FW: Guide to Participation in the Planning Process

>This is Gene Stone, 34 Merrill Street.

1 FRONT (EAST) ELEVATION
SCALE: 1/4" = 1'-0"

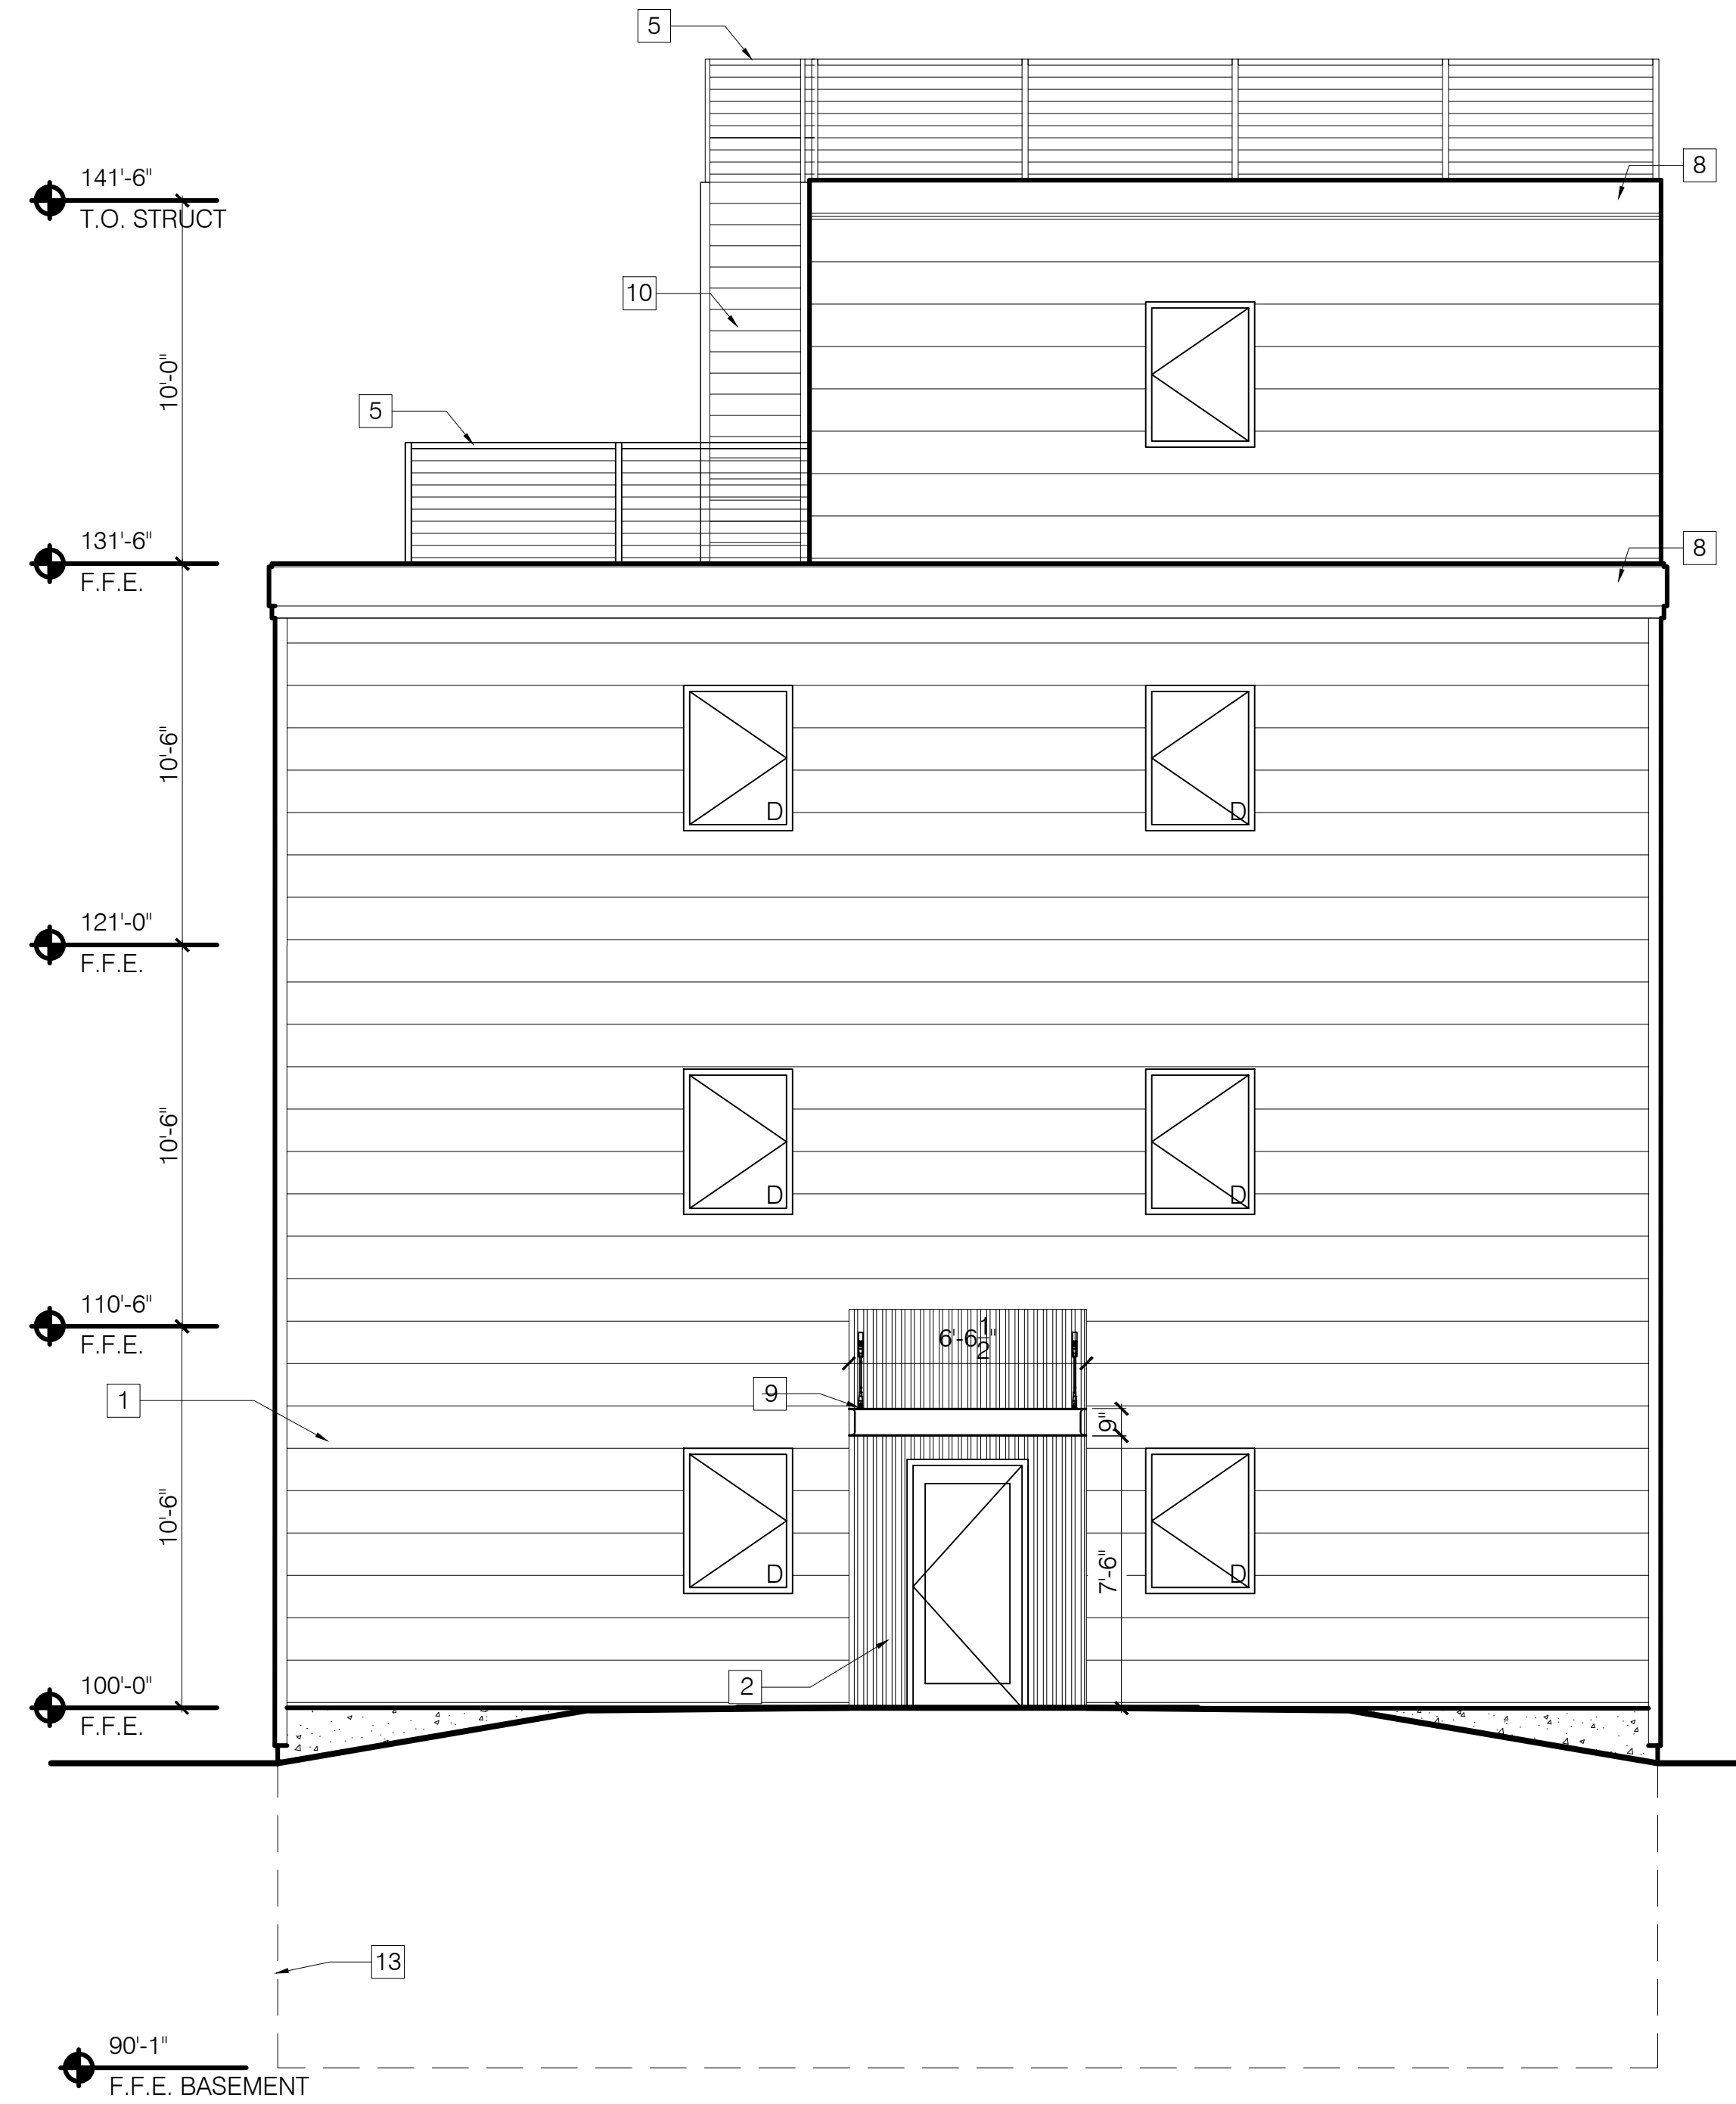
>D: The front of the building is the showing of the rail on all levels,

>for a

>Deck?

1 NORTH ELEVATION
SCALE: 1/4" = 1'-0"

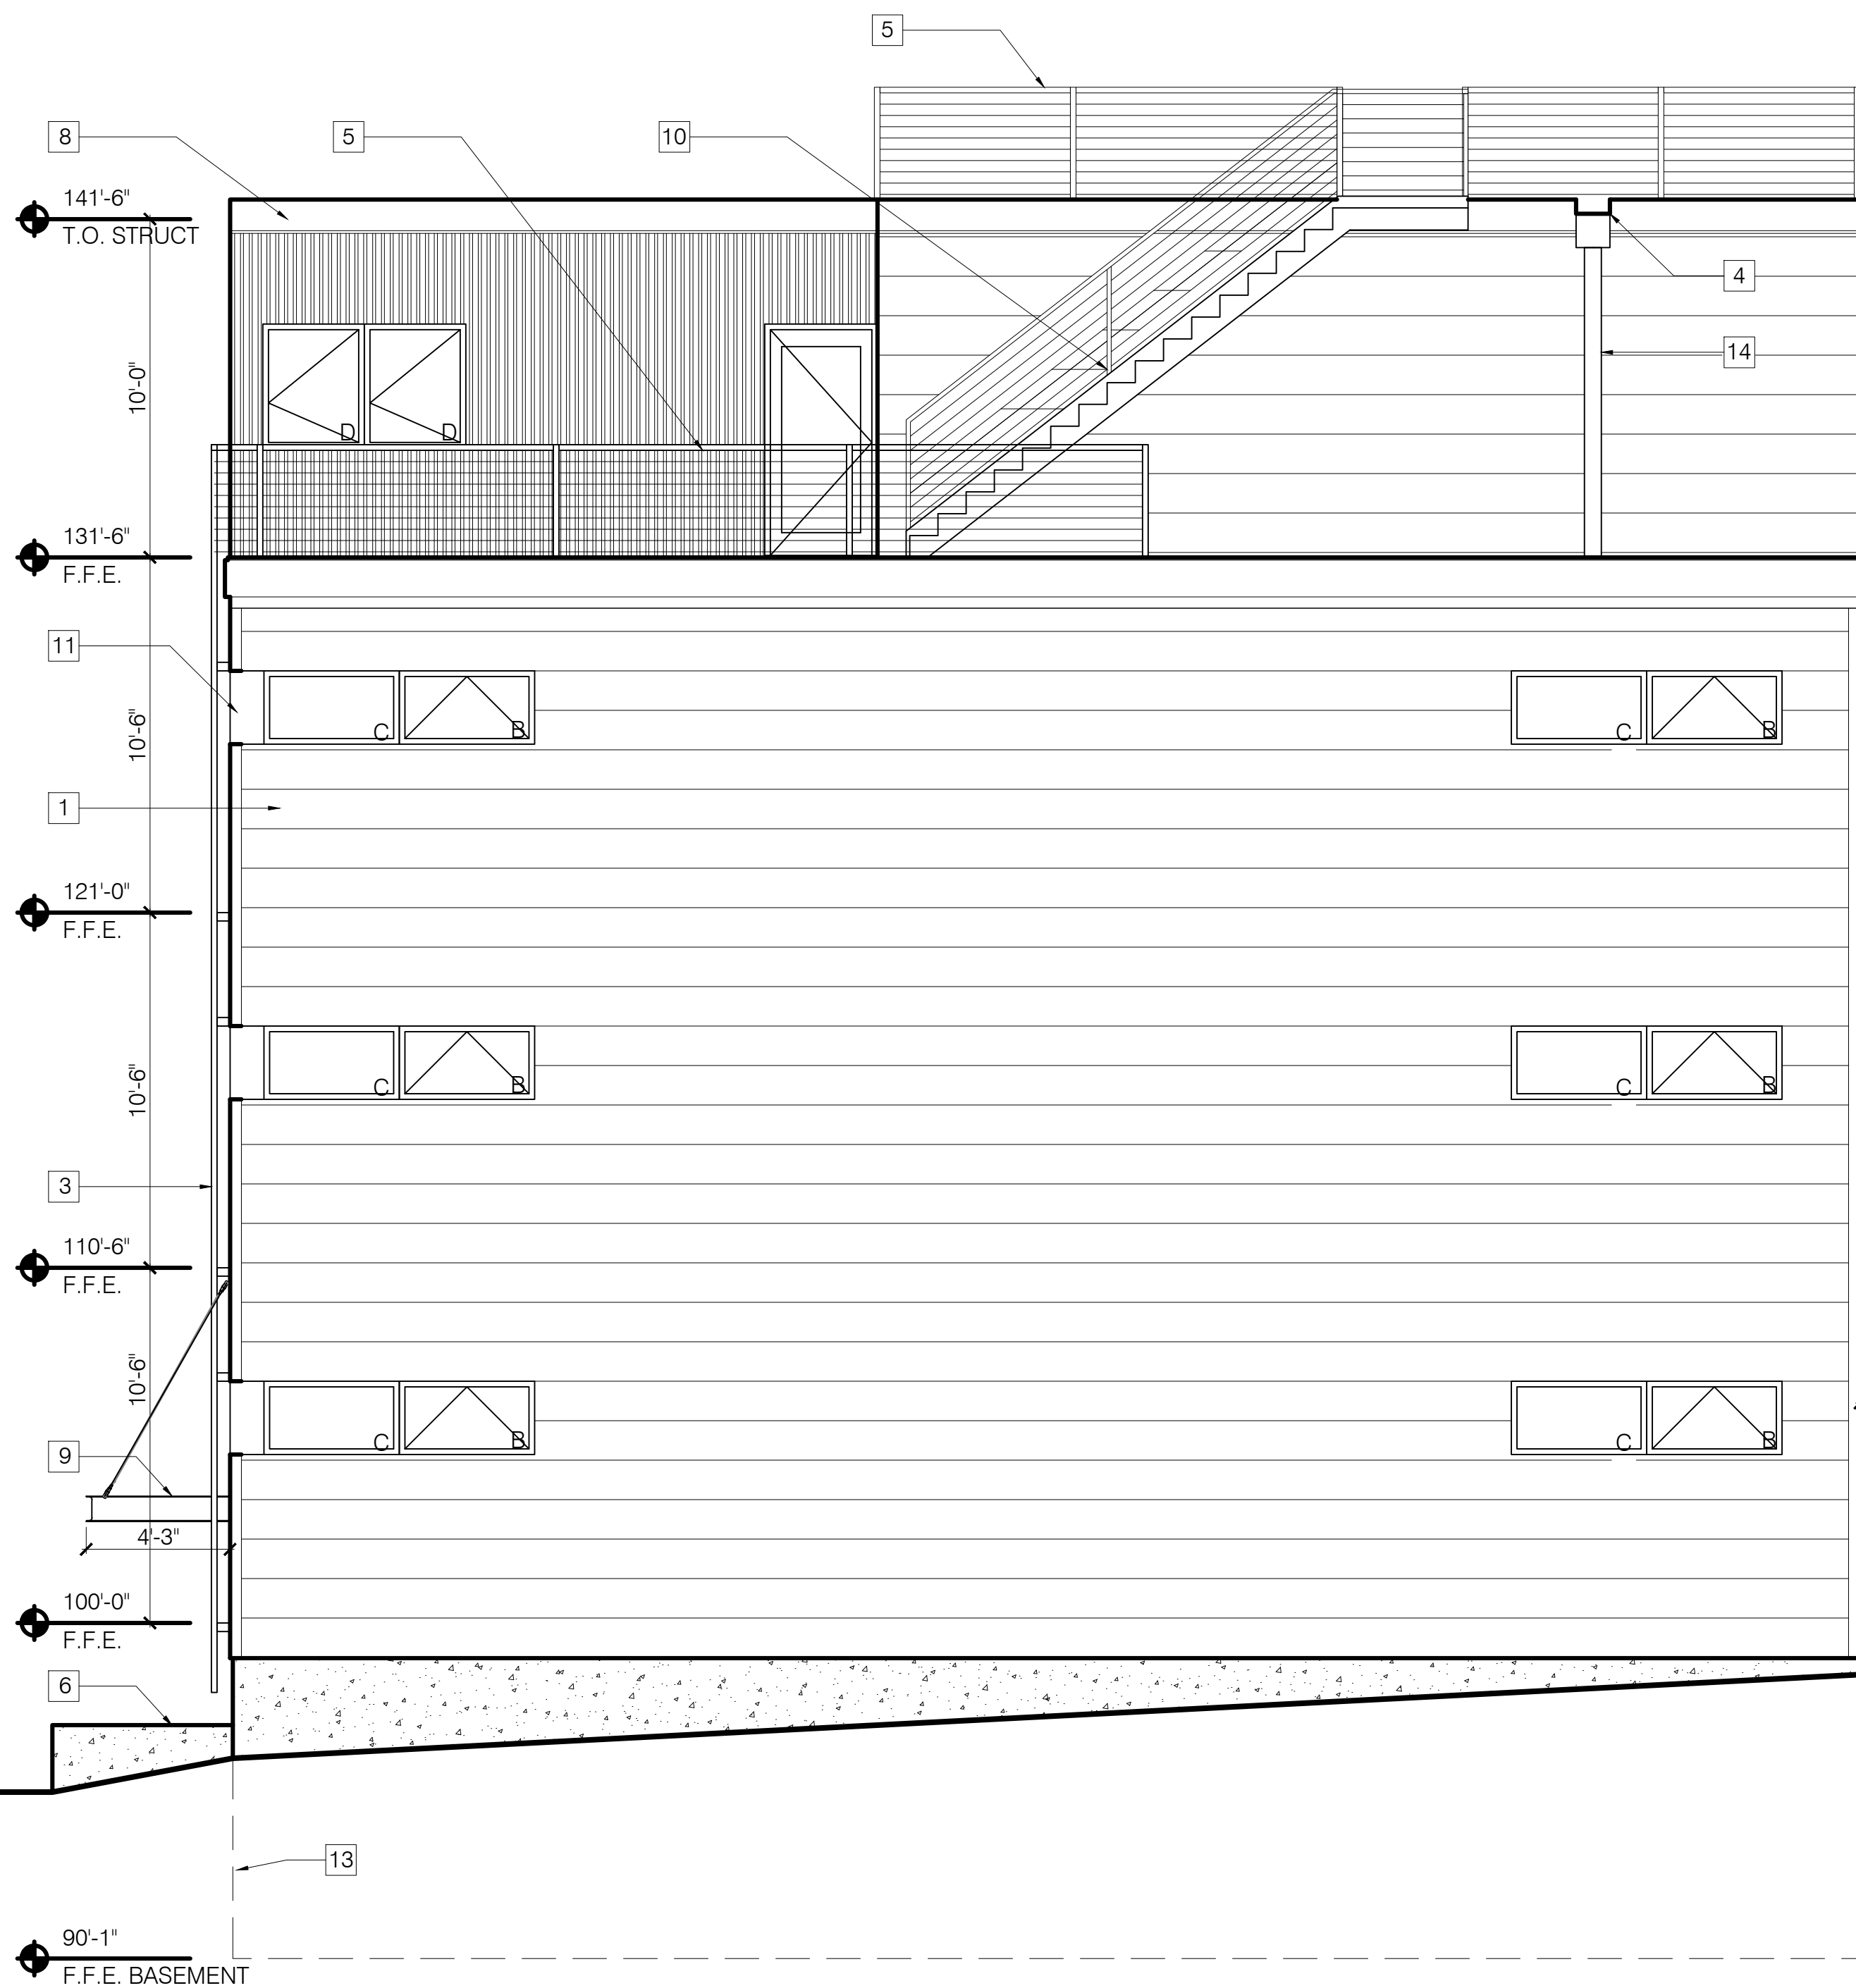
>C: My issues are. Being blind, My son has told me according to the

>illustration of the building going up next to my house/driveway. That the

>side facing my house, looking from the front, it would be the right side,

>to my Privacy fence/Chain-link fence. Is the concern 5 feet. I did not
